DECISION DELEGATED TO DEVELOPMENT MANAGER

Application No: H15-1028-20 **Applicant:** Quadring Developments
Proposal: Erection of 5 dwellings - outline approval H15-0463-18
Location: 70 Main Road Quadring Spalding
Terminal Date: 28th February 2021

Reserved matters approval is sought for the erection of 5 dwellings at 70 Main Road, Quadring. Outline planning permission was granted under application ref. H15-1068-17 and amended under H15-0463-18.

Drainage Plan

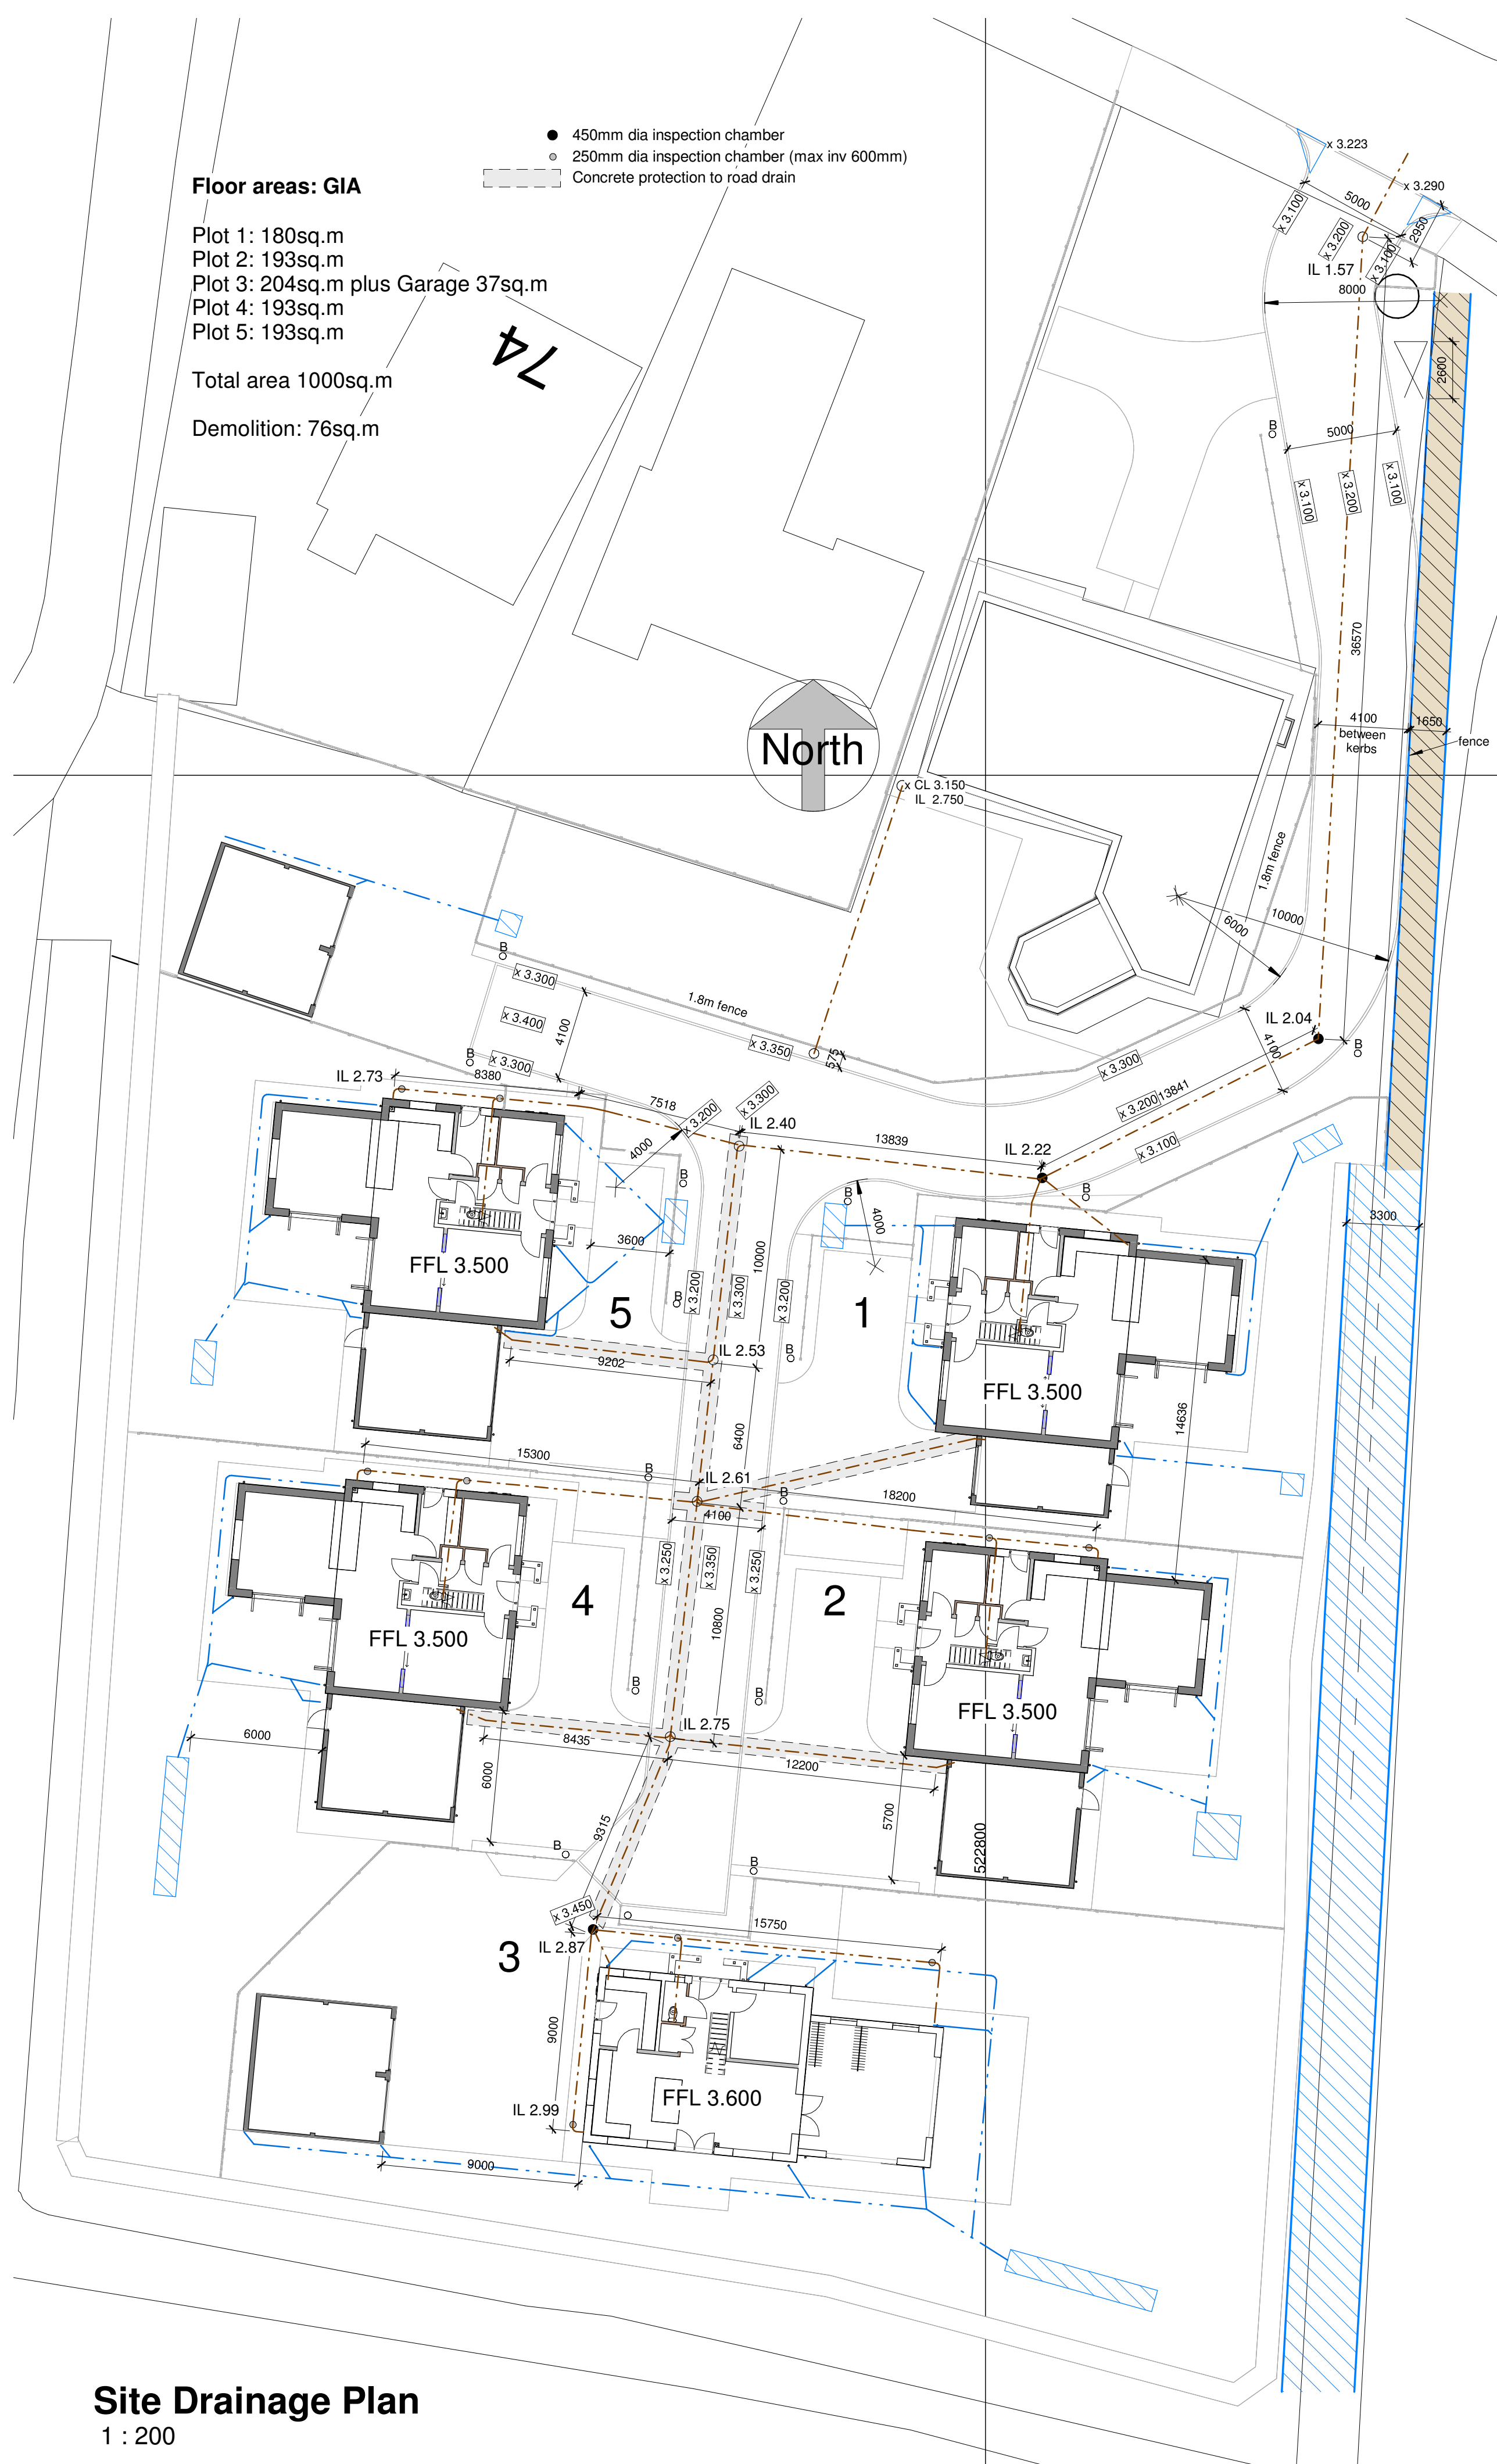
Condition 8 of H15-0463-18 requires that finished floor levels (FFLs) of the dwellings are raised 300mm above existing ground level. It is noted that the submitted block plan does not appear to show finished floor levels as being raised to this extent (only approx. 150-200mm), therefore a further condition will be added reiterating this point.

Foul water would be discharged into the existing Anglian Water network in Main Road and roof/surface water to soakaways. It is intended that surface water run off from the private drive will infiltrate into the verges. The IDB are content with the surface water drainage arrangements.

Given the above, it is considered that the drainage proposals accord with Policies 2, 3 and 4 of the Local Plan which require proposals to provide appropriate means of drainage. The need to raise finished floor levels to 300mm above existing ground level will be reiterated via condition.
